**From:** Laura Gibbons <Laura.Gibbons@arun.gov.uk>  
**Sent:** 19 October 2021 10:19  
**To:** Planning.Responses <Planning.Responses@arun.gov.uk>  
**Cc:** Anita Gardner <Anita.Gardner@arun.gov.uk>  
**Subject:** RE: Planning Consultation on: M/130/21/DOC

**Application No:** M/130/21/DOC

**Site Address:** 8 Manor Way Elmer Middleton-On-Sea PO22 6LA

**Description of Works:** Approval of details reserved by condition imposed under ref M/86/20/PL relating to Condition No 3 - surface water drainage.

REAR GARDEN GROUND FLOOR TERRACE
CONSTRUCTION PERMEABLE BLOCK PAVING
(Scale 1:20)

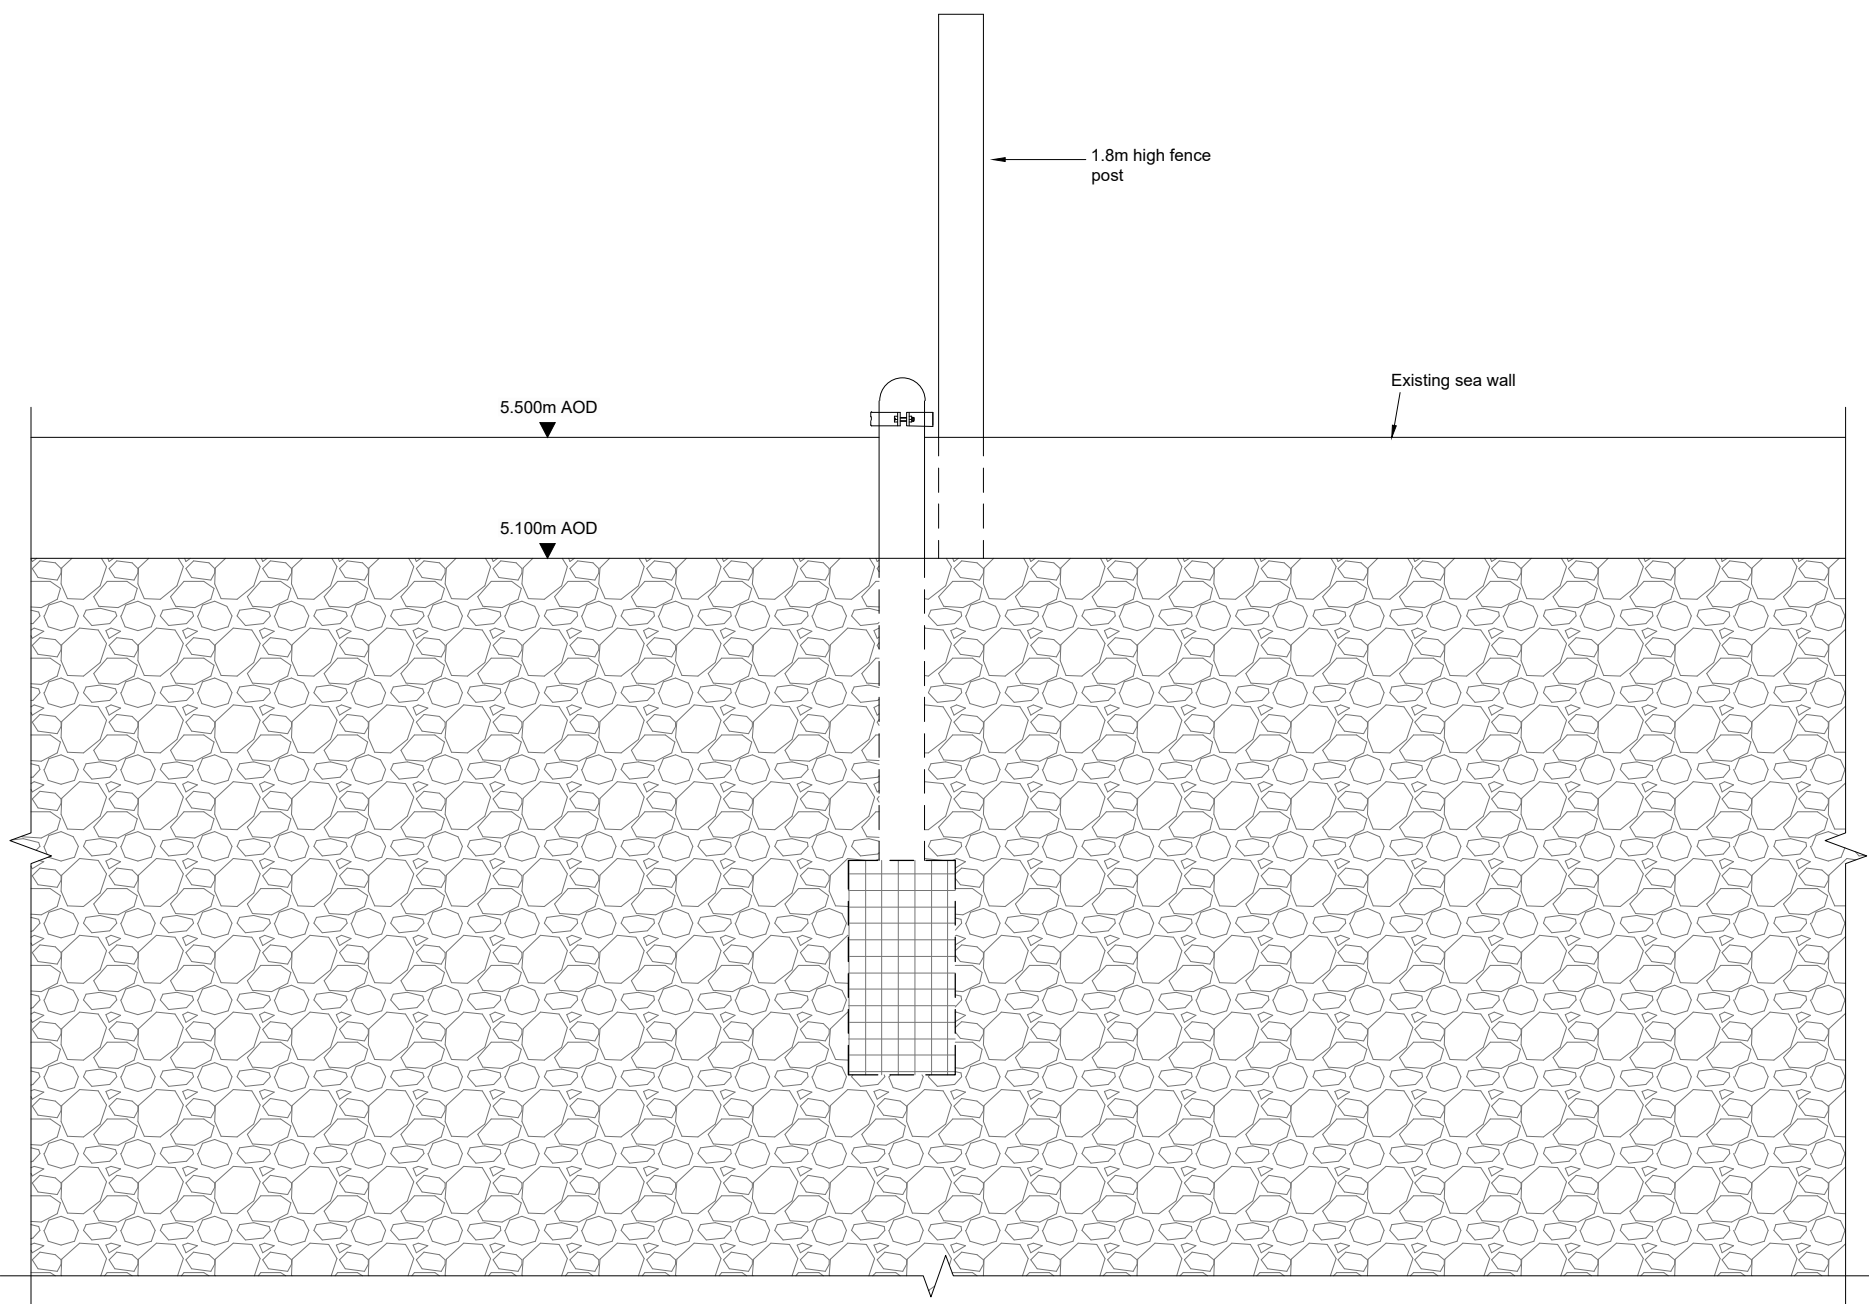
Please can an impermeable liner be provided to the sides of the rear garden ground floor terrace to ensure that water does not travel through the sides of this raised area and infiltrates through the bottom only.
